**re: Grading, Servicing and Landscape Plan Review**  
Proposed Commercial Building  
1826 Robertson Road - Ottawa, Ontario

**date:** February 8, 2024

**file:** PG6426-MEMO.01

LANDSCAPE PLAN  
SCALE: 1:250

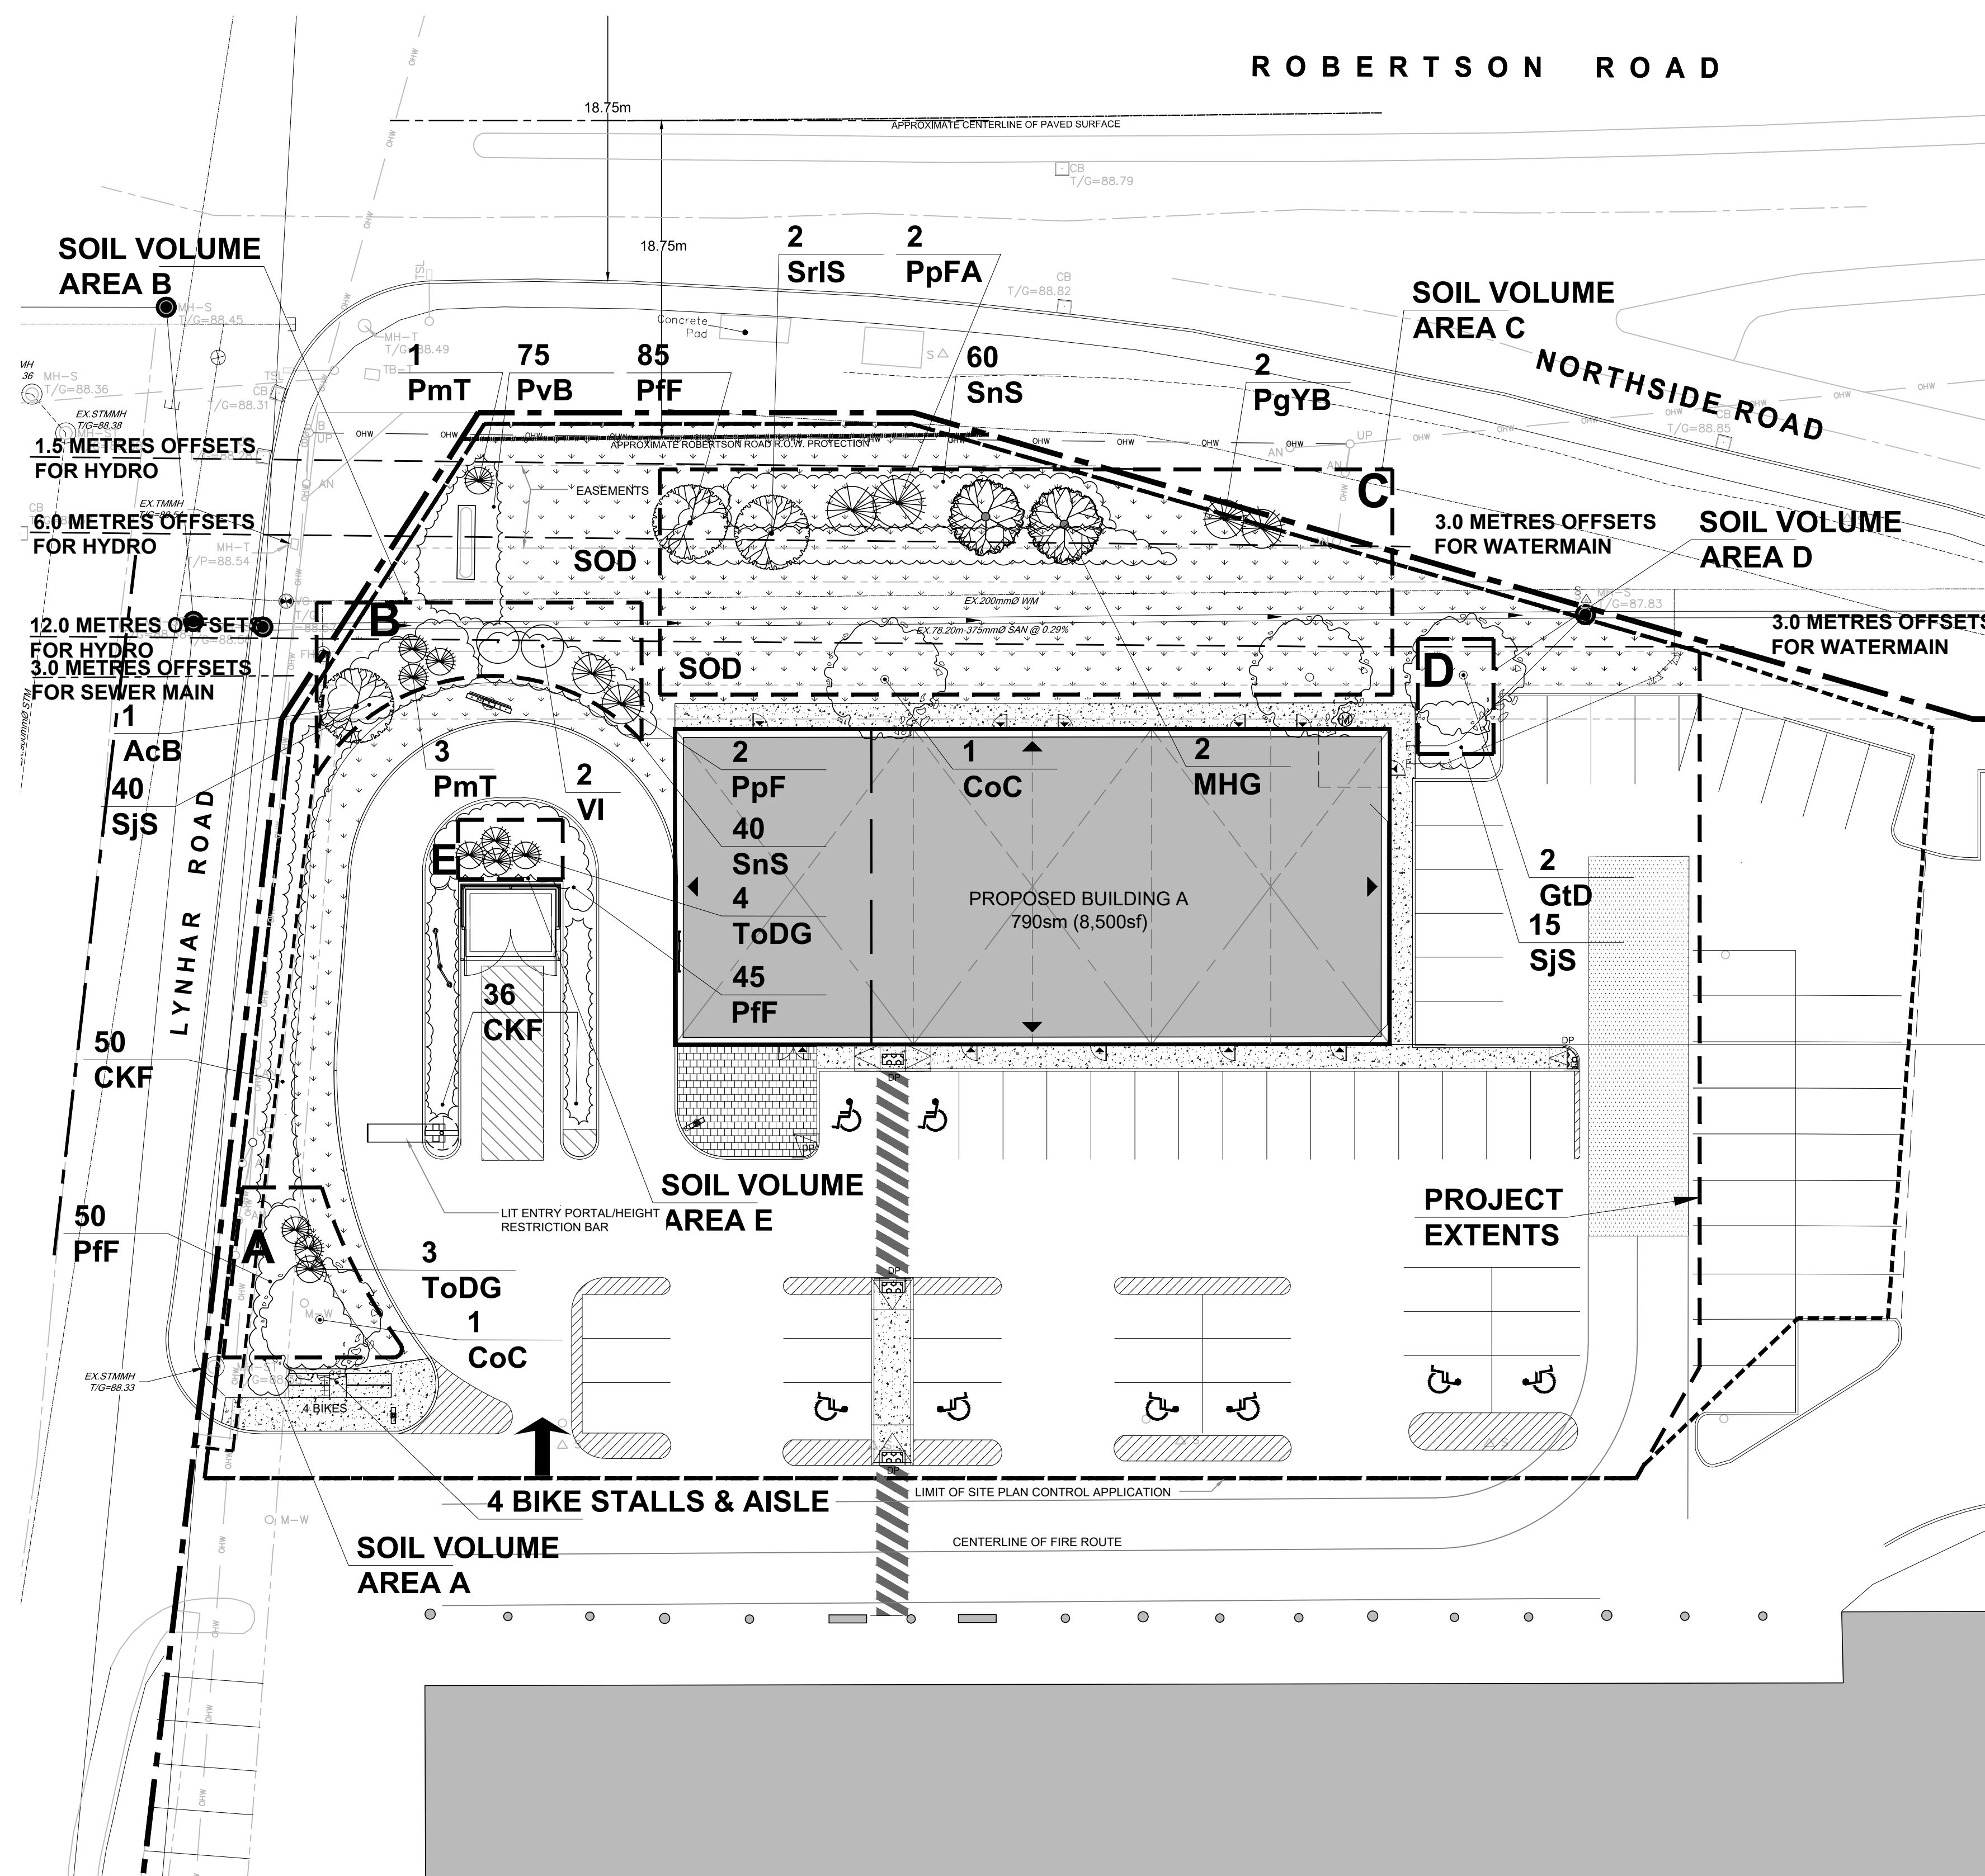
In reviewing the available Landscape Plan, referenced above, trees located along the northern boundary of the proposed building with a setback of less than 4.5 m must either be re-located to a setback of 4.5 m or greater, or replaced with shrubs or bushes which have a root depth of less than 1 m.
